Conservation Area Advisory Committee

A/76/15/PL

Single storey rear extension & re-modelling of front car park area to increase number of spaces from 25 to 32. This application affects the character & appearance of the Angmering Conservation Area.

Angmering Manor
High Street
Angmering
BN16 4AG

Tree Protection Plan

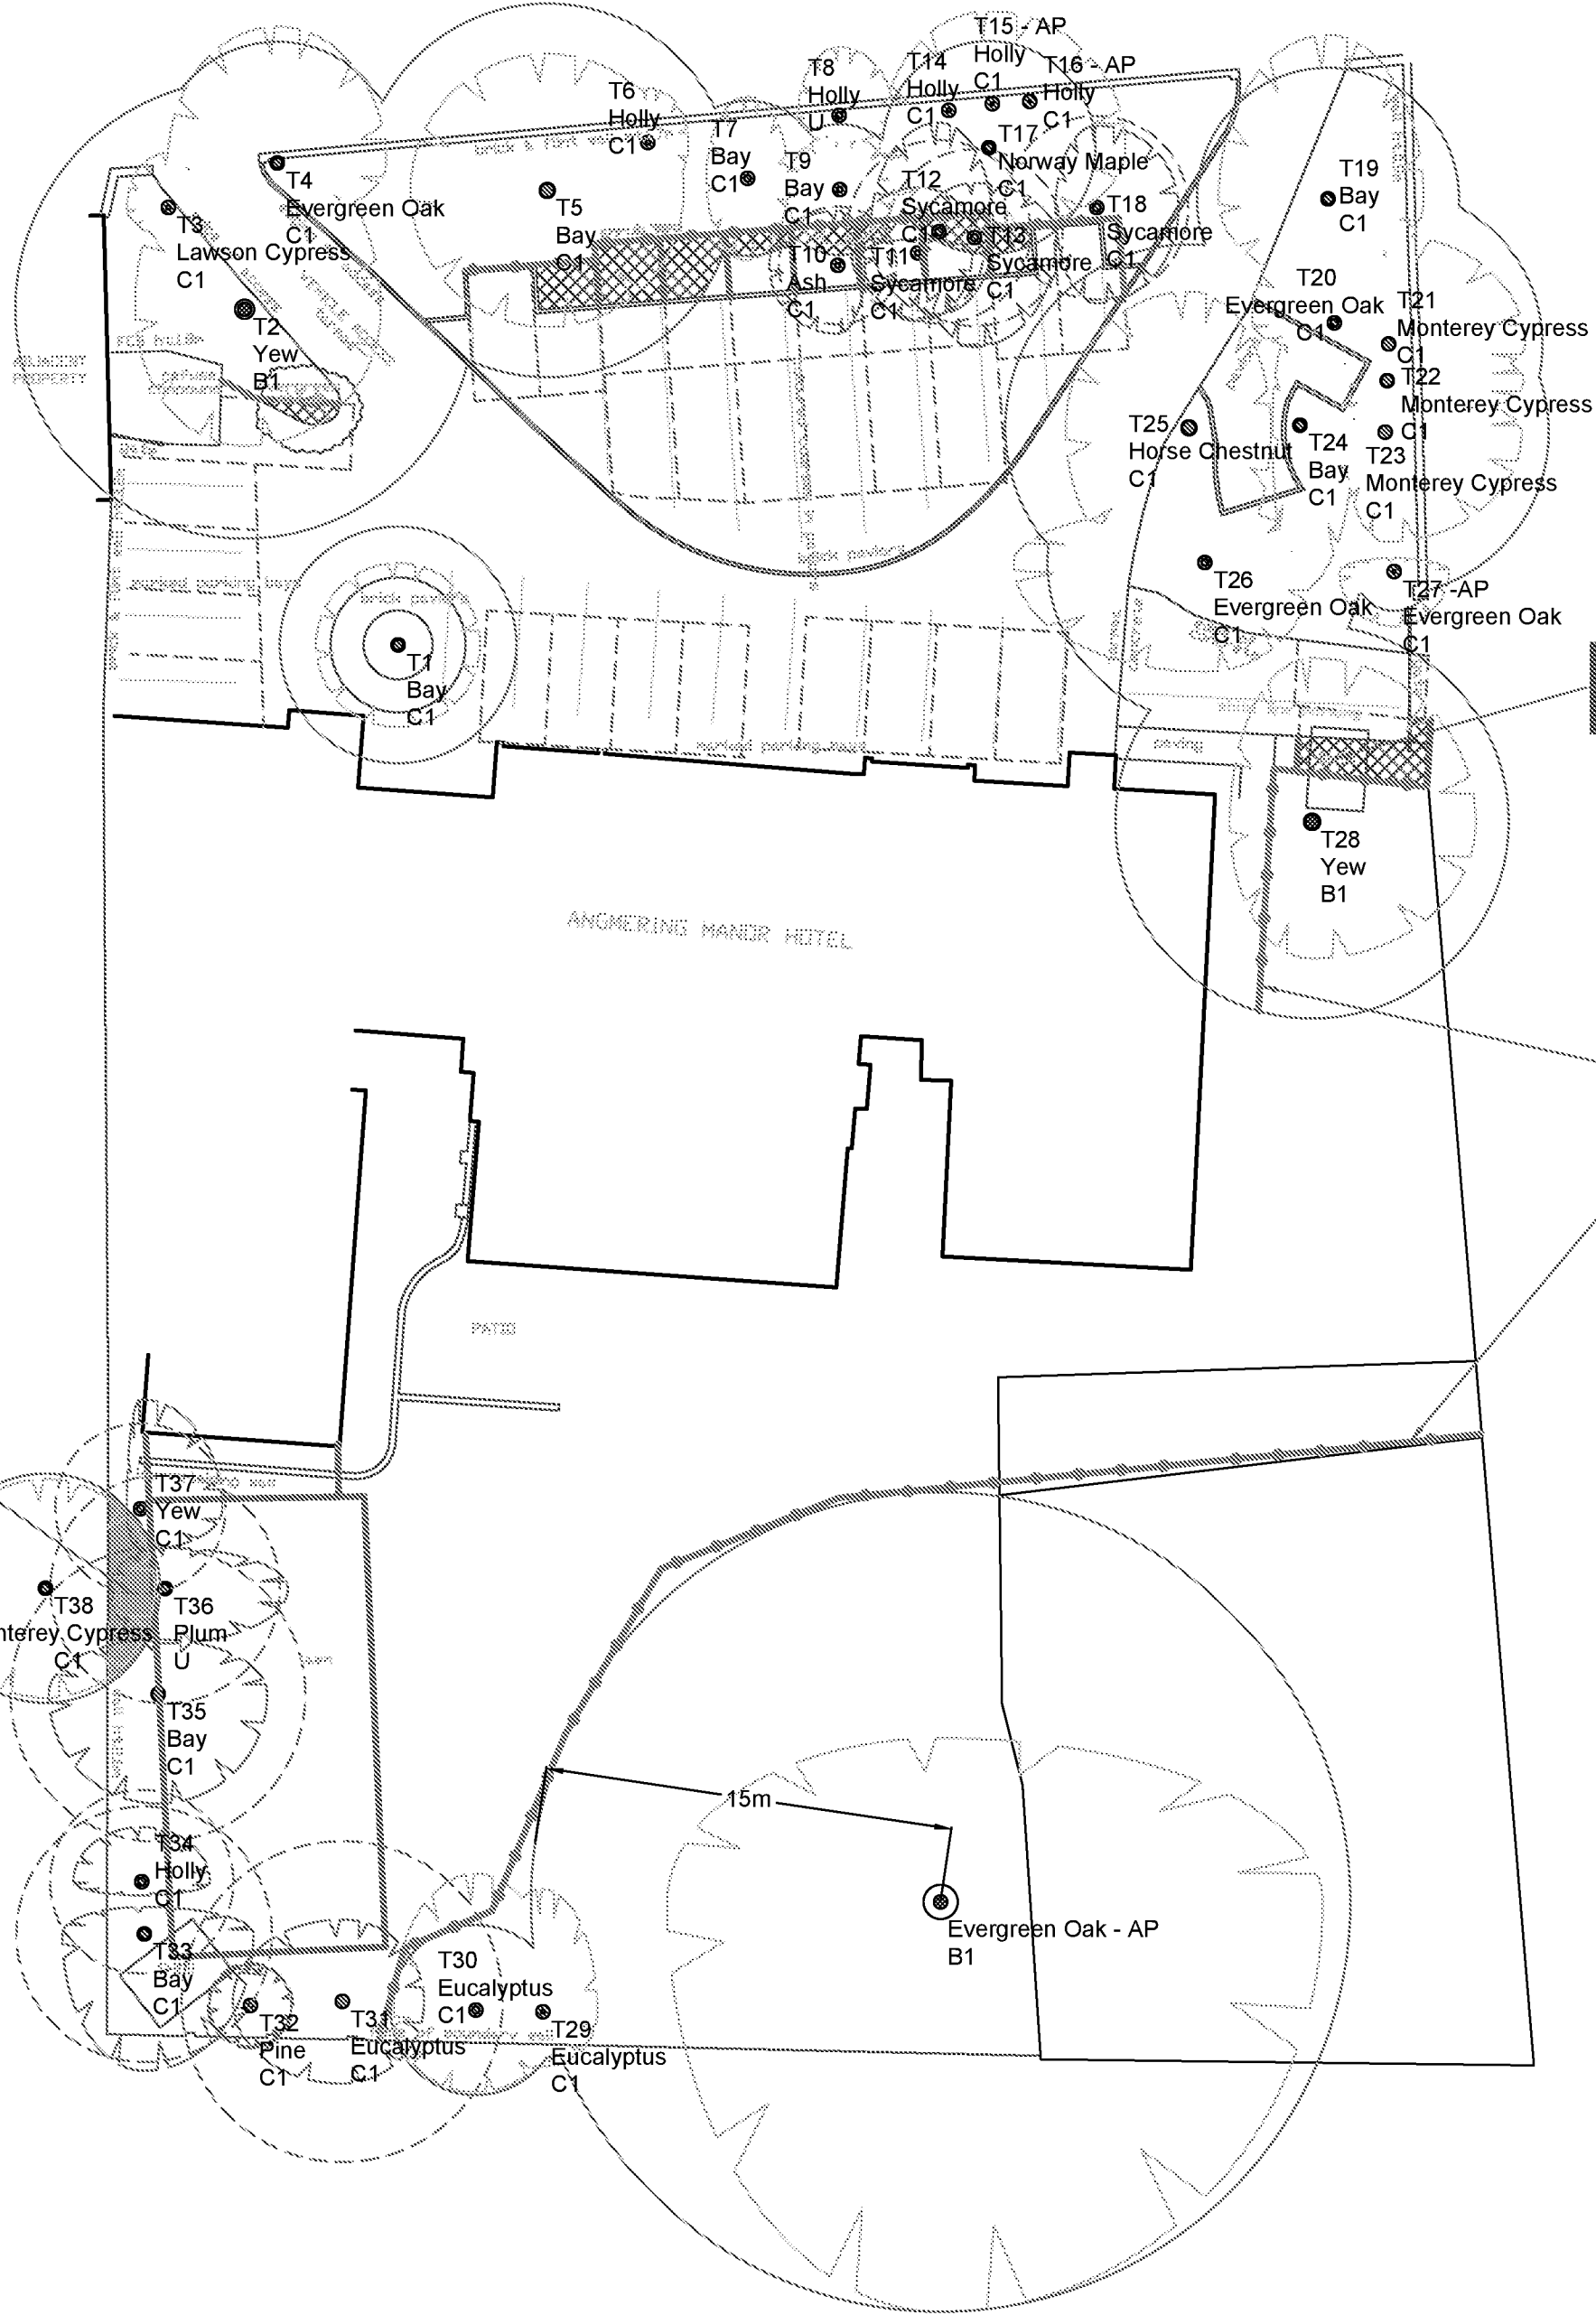
Careful assessment needs to be made with regard to the quality of the trees to be removed & their contribution to the street scene
